**GSK, Stockley Park, Iron Bridge Road, West Drayton, UB11 1BT
Town and Country Planning Act 1990 (as amended) Section 96A Non Material Amendment Application
to Planning Permission 39207/APP/2020/2188**

On behalf of our client, Prologis UK, we enclose an application for a non-material amendment (Section 96A application) to planning permission 39207/APP/2020/2188. The application proposes non-material amendments to the approved drawings following a detailed design review by the project team.

DATE	SCALE	DRAWN
JUNE 2020	1:1000@A1	PF
		STATUS CHECKED
	PLANNING MS/GZ/SD	
DRAWING NUMBER 30928-PL-201E

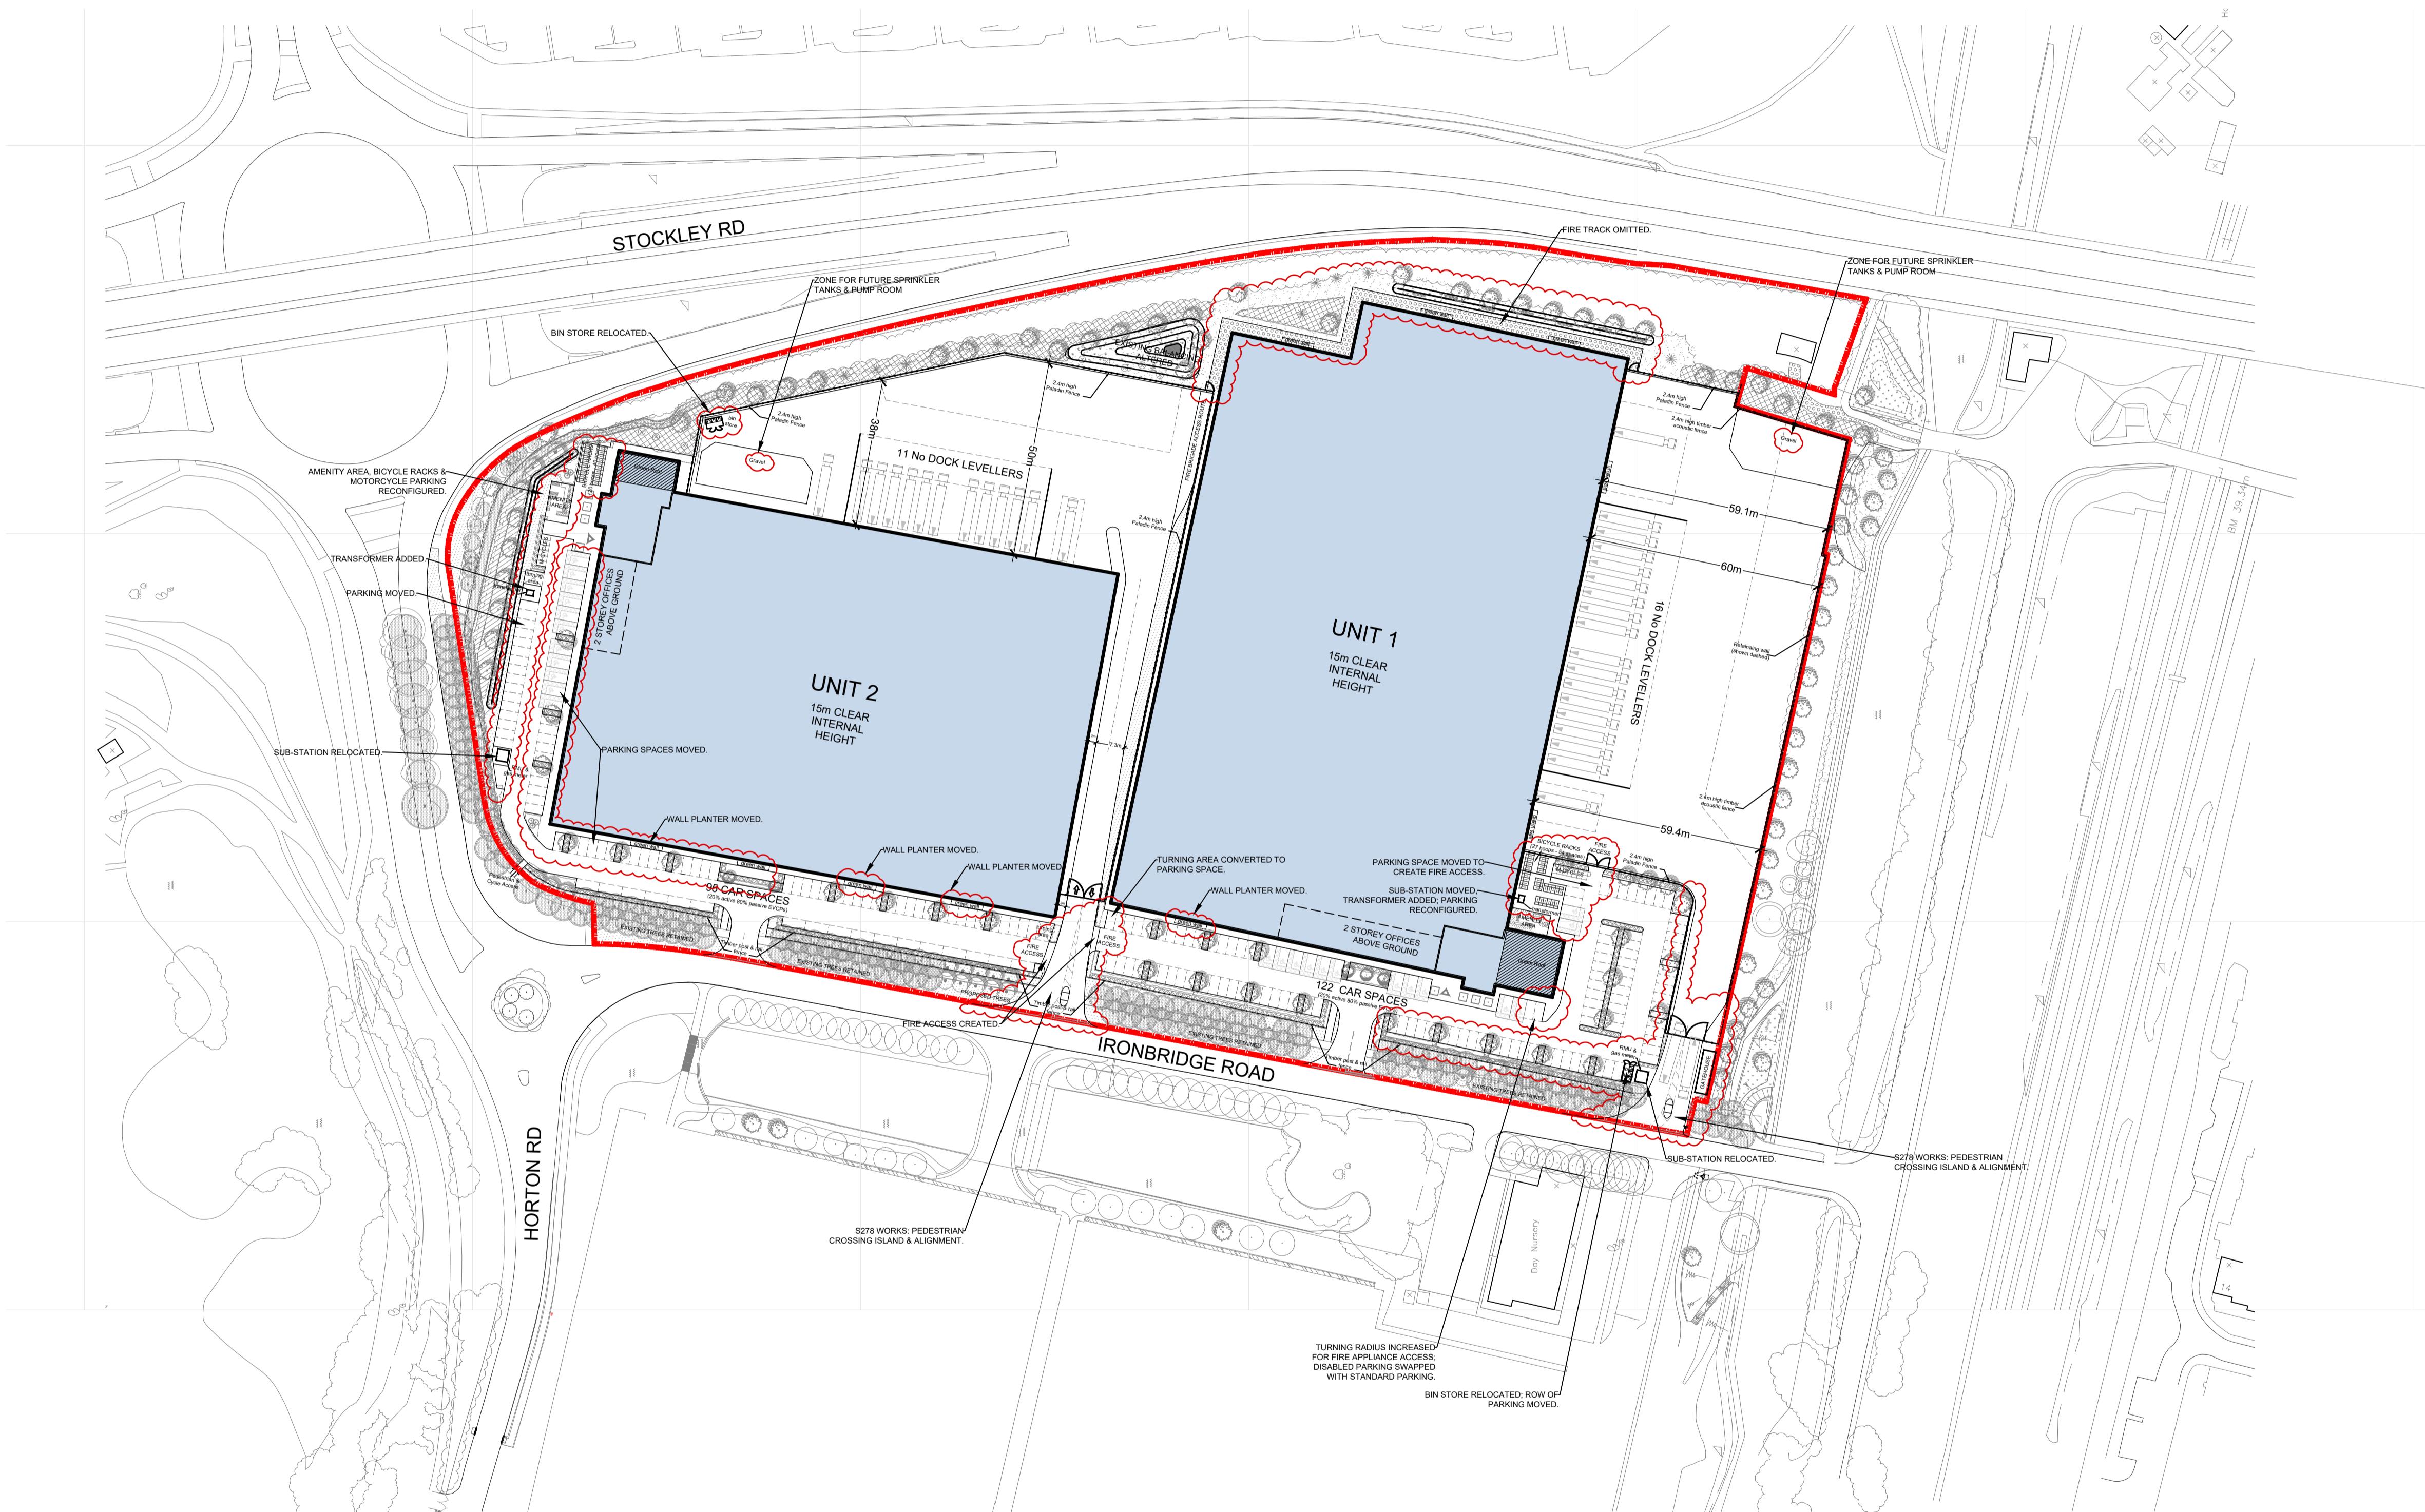
30928-PL-201E Site Layout Plan

- Amended vehicular access points;
- Sub-stations amended to RMU and Gas Meter and Transformer;
- A zone in the service yard to be designated as a gravel area;
- Paladin fence added between Units 1 and 2;
- Fire track to the east of Unit 1 omitted. A new fire access is created between the service yard and car park and at the northern end of the car park;
- Unit 1 disabled parking swapped with standard parking;
- Unit 1 bicycle racks and motorcycle parking reconfigured;
- Unit 1 bin store moved from the service yard to car park;
- Fire access created between Unit 1 service yard access and southern end of the car park;
- Unit 2 car parking bays reconfigured;
- Unit 2 amenity area, bicycle racks, and motorcycle parking reconfigured;
- Unit 2 bin store moved to northern end of the service yard.

Amended vehicular access points

The consented vehicular access points located at the south and southern boundaries of the site have been amended to align with the consented s278 works, which include the addition of pedestrian refuge islands and changes to kerb alignments. The proposed amendments to the vehicular access points are minor and do not compromise the highway safety of the consented access.

Provision of designated gravel area located in the service yards

A small portion of each service yard has been designated as a gravel area to accommodate future sprinkler tanks and a pump room. An application for the sprinkler tank and pump room is yet to be prepared at this stage and does not form part of this NMA application. The designated areas have been positioned in locations that will not adversely impact the usable service yard area or vehicle turning area.

Addition of paladin fence between Units 1 and 2

A 2.4m high paladin fence is proposed between Units 1 and 2 in order to create a clear boundary between the units should they be occupied by different tenants. The fence will match the height and appearance of the consented fence located at the site boundary and car parking areas and as such will not result in any material visual change.

Provision of new fire accesses at the car parking areas for Units 1 and 2

It is proposed that 3no. fire accesses are provided across the site, two of which are located adjacent to the southern site access and the third of which is located to the north of the Unit 1 car park. These accesses will provide suitable access for fire appliances for both Units.

Unit 1 and 2: Car parking reconfiguration and bin store relocation

A number of changes are proposed at the parking and bin store areas for each Unit, comprising the following:

- Unit 1 disabled parking swapped with standard parking;

- Unit 1 bicycle racks and motorcycle parking reconfigured;
- Unit 2 car parking bays reconfigured;
- Unit 2 amenity area, bicycle racks, and motorcycle parking reconfigured;
- Unit 1 bin store moved from the service yard to car park;
- Unit 2 bin store moved to northern end of the service yard.

The proposed changes aim to provide easier access to the site for emergency vehicles and refuse disposal vehicles. The overall number of car, motorcycle, and cycle parking will remain the same as consented as such will not constitute a material change to the parking arrangements on site.
